City of Albuquerque

July 19, 1985

RE: DRAINAGE PLAN FOR 4th STREET COMM. BLDG. (J14/D53) RECEIVED JUNE
27, 1985

APPROVALS	NAME	DATE	TITLE: COMMERCIAL BLD. 1223 FOURTH ST. N.W. ALB. N.M.
A.C.E./DESIGN			PORT BLOCK 5 ROMERO ADDN
INSPECTOR			ROBERT LUEL 600 1st ST NW SUITE 100
A.C.E./FIELD			PERMIT NO.
			SHEET 3 OF 3
			MAP NO. J-14

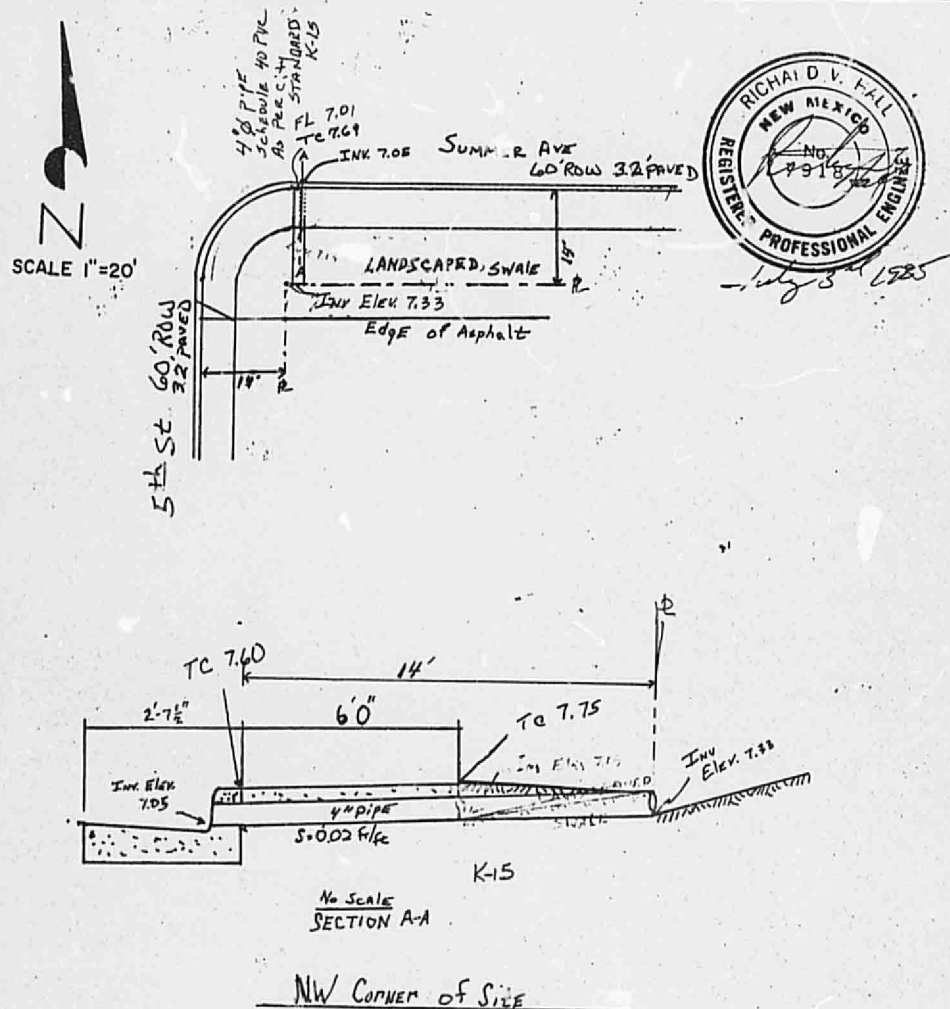
Please provide a current plat of the property. The zone atlas map does
not show a legal alley running north & south through the property.

Also, it appears the paving may be taking place on adjacent property rath-
er than the business property.
